MESA DEL SOL
ARCHITECTURAL CONTROL COMMITTEE
SITE DEVELOPMENT PLAN REVIEW

**RE: Mesa Del Sol Self Storage
5500 Turing Dr. SE
Grading and Drainage Plan
Engineer's Stamp Date: 5/7/2025
Hydrology File: R16DA1004**

**Re: Mesa Del Sol Self Storage
 5500 Turing Dr. SE
 Grading and Drainage Plan
 Engineer's Stamp Date: 01/15/2025
 Hydrology File: R16DA1004**

Here are the responses to the comments provided on March 21, 2025 in regards to an **Updated Grading & Drainage prior to continuing onsite grading and foundation work.**

SHEET NUMBER

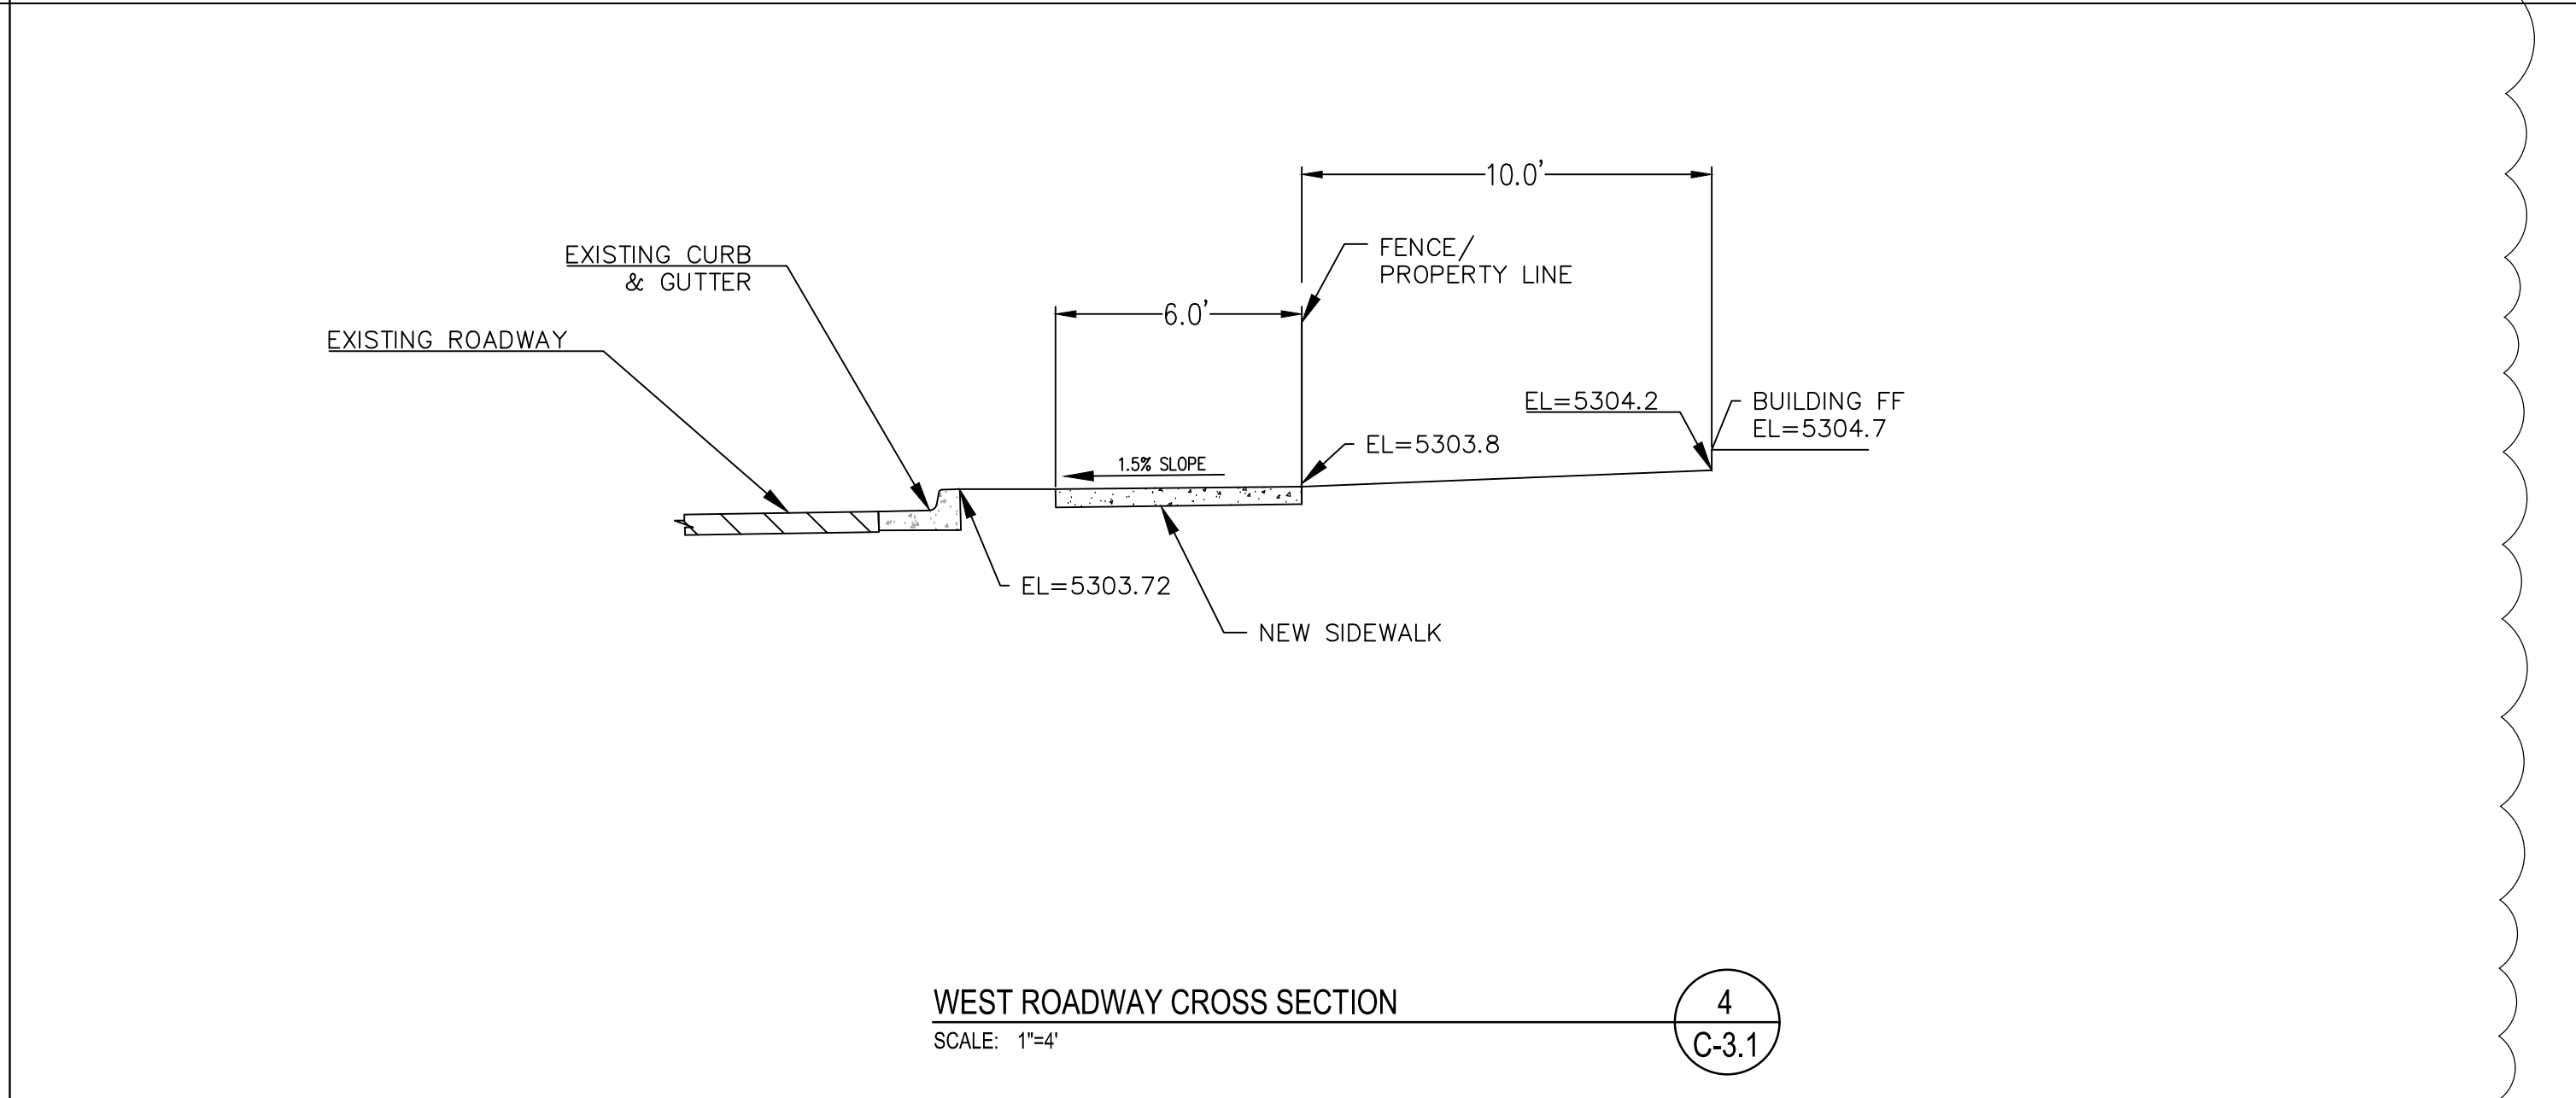
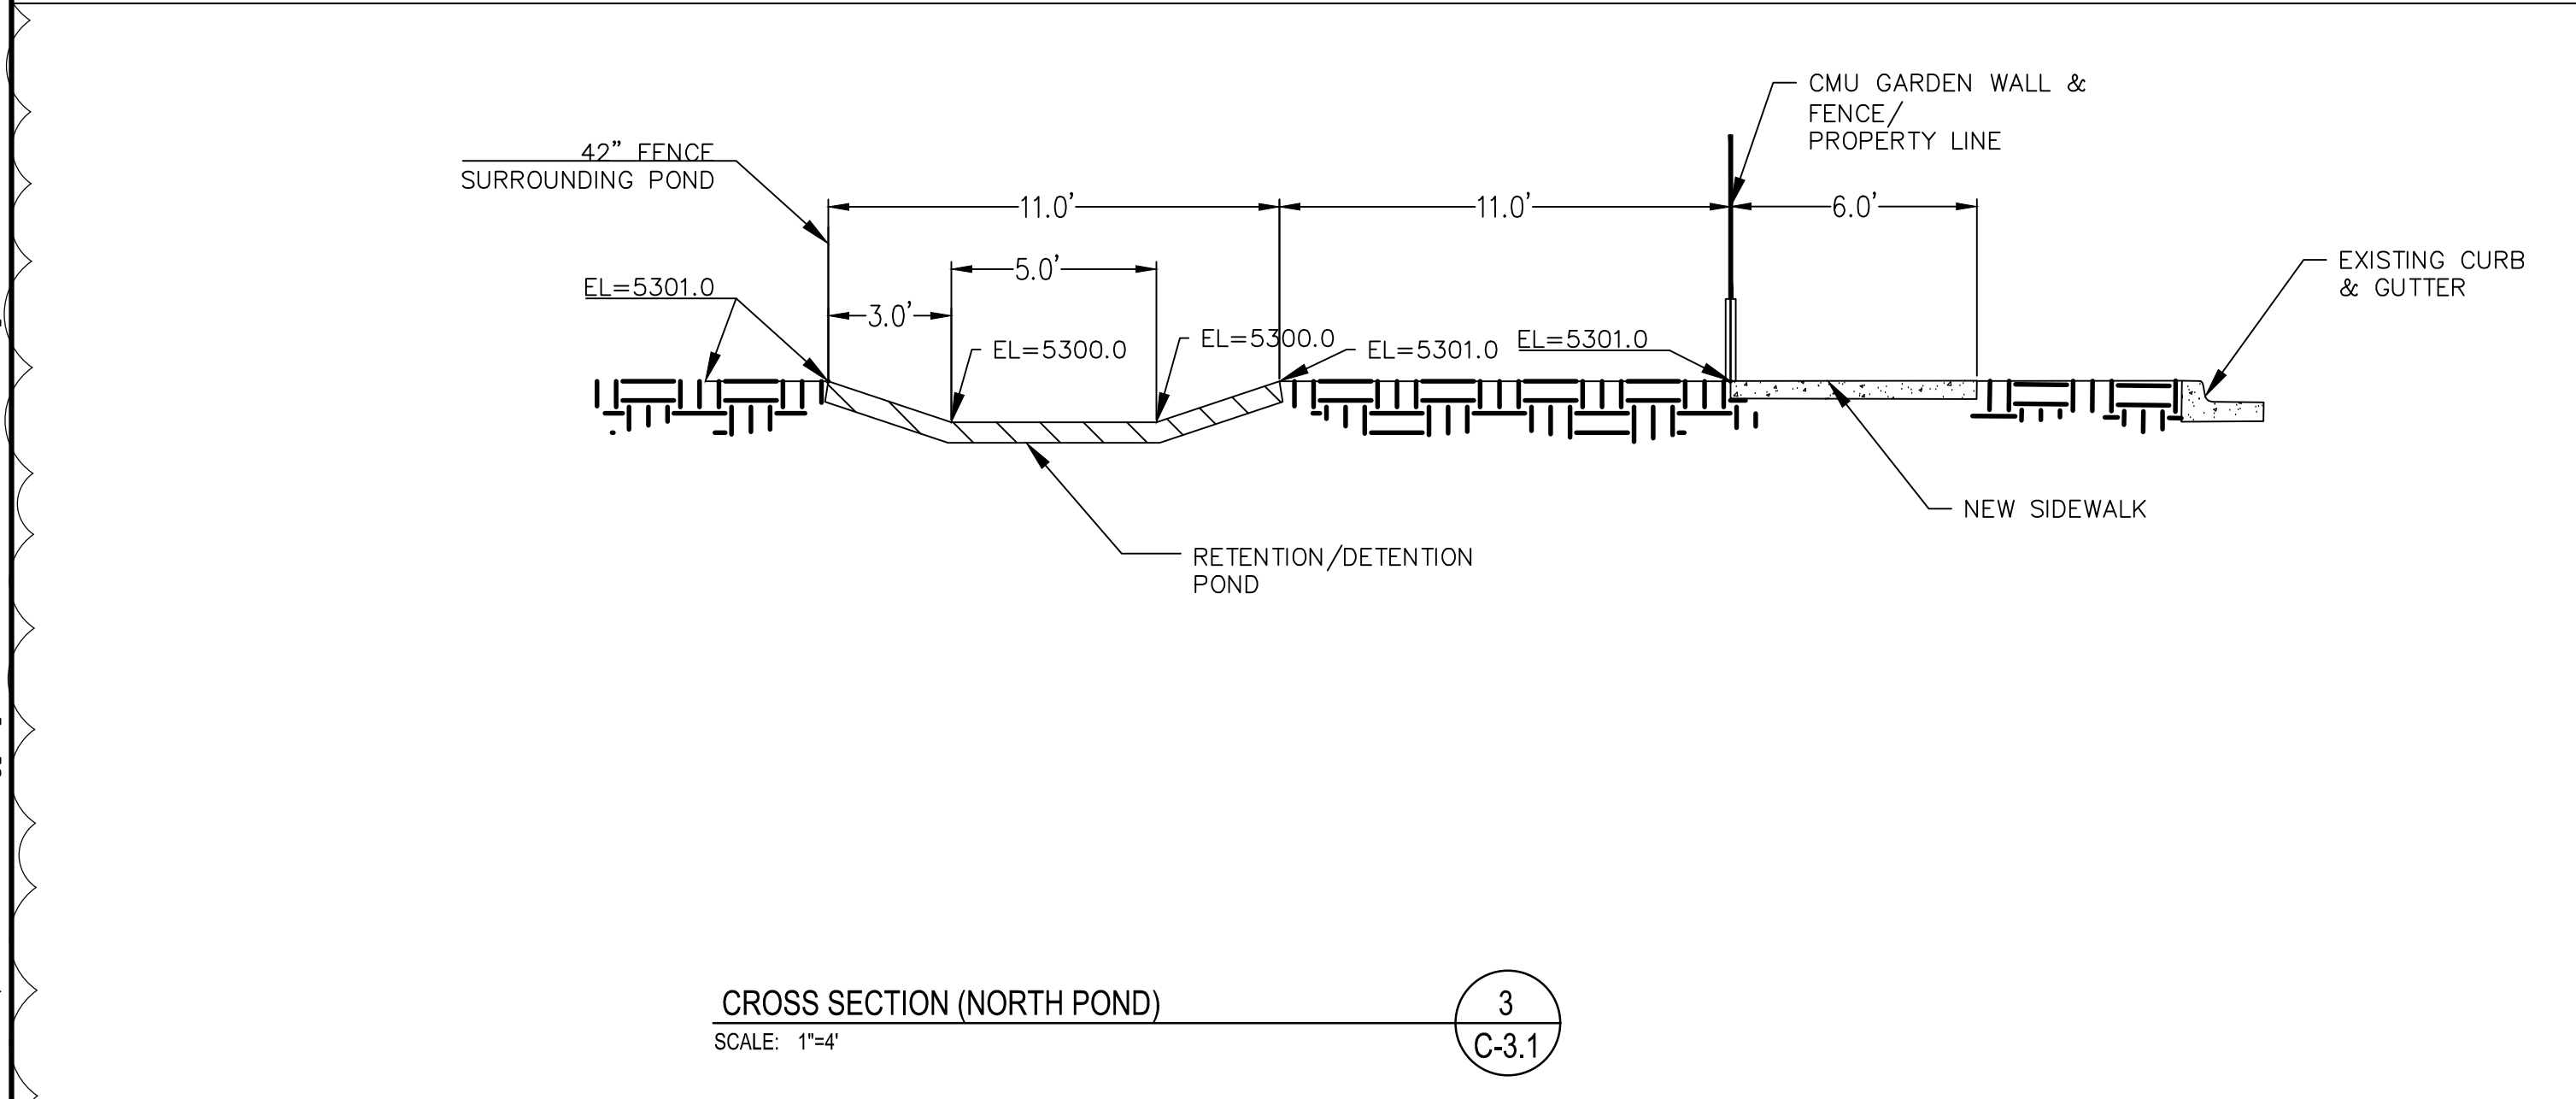
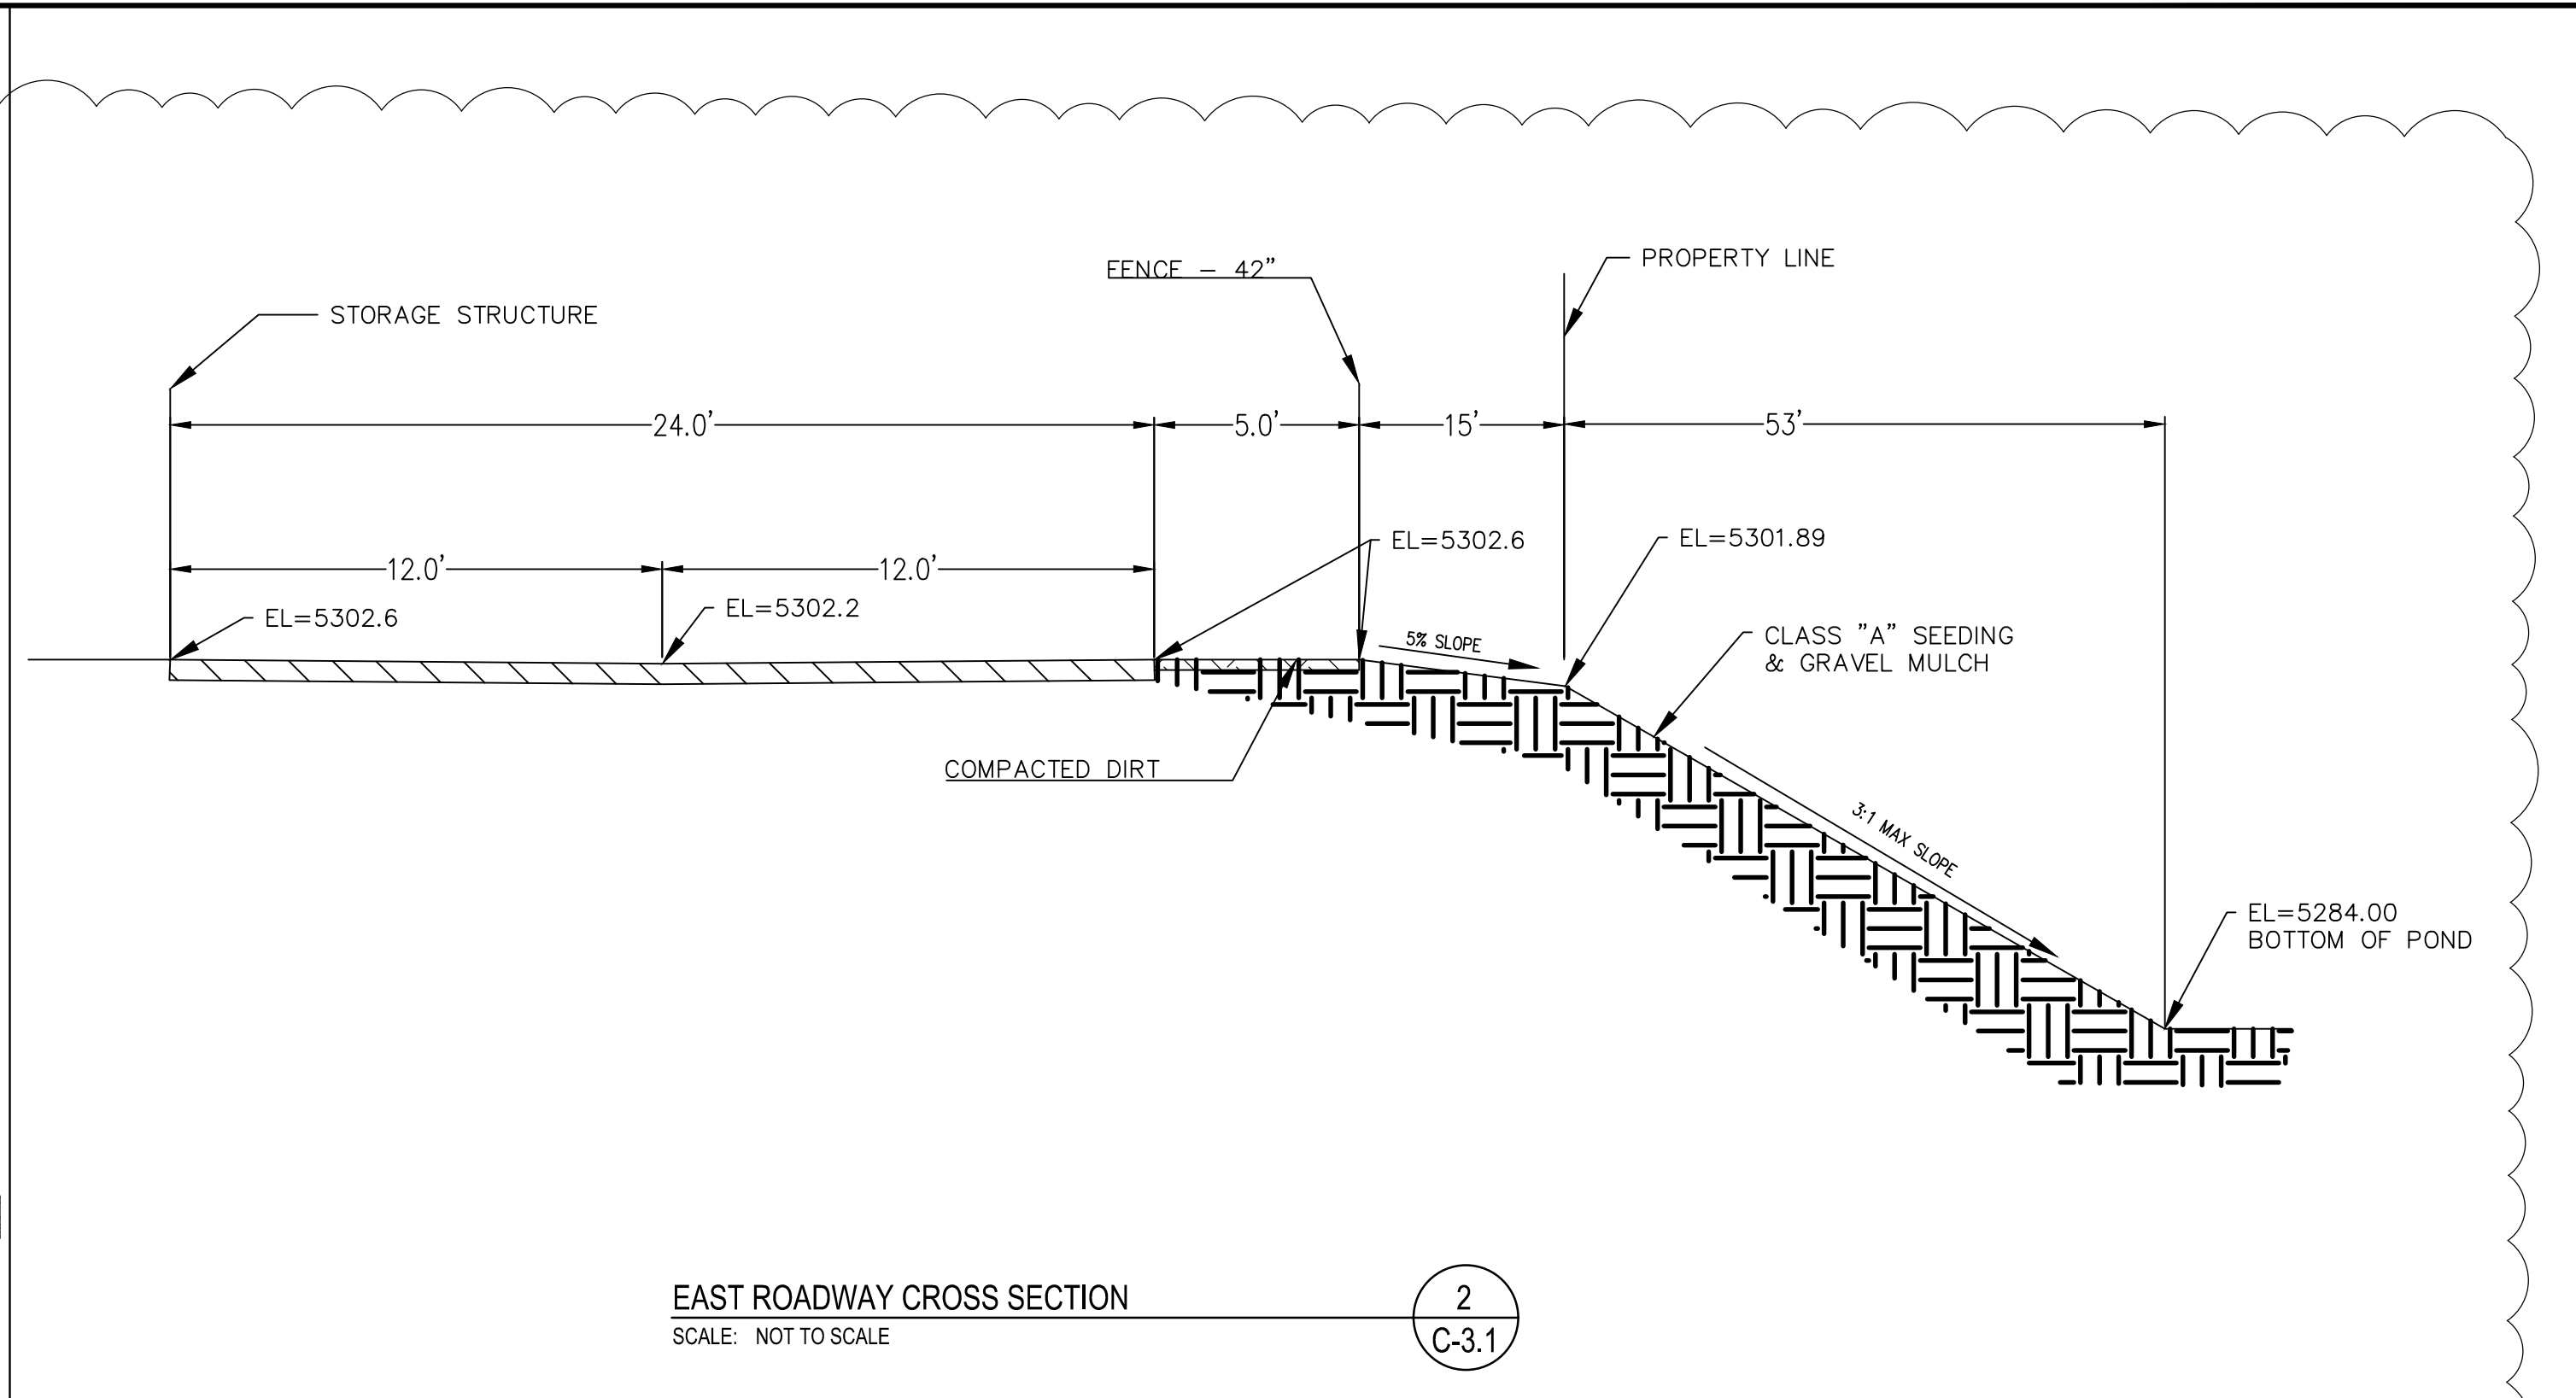
8. Due to the proposed retaining wall in Section 1 of C-3.1, provide an additional cross-section showing the existing storm drain manhole and pipe extension through the proposed retaining wall and into the retention basin at the southeast corner of the project.
Concur. Additional section has been added, see revised sheet C-3.1 & C-3.2. Retaining wall removed from revised design.
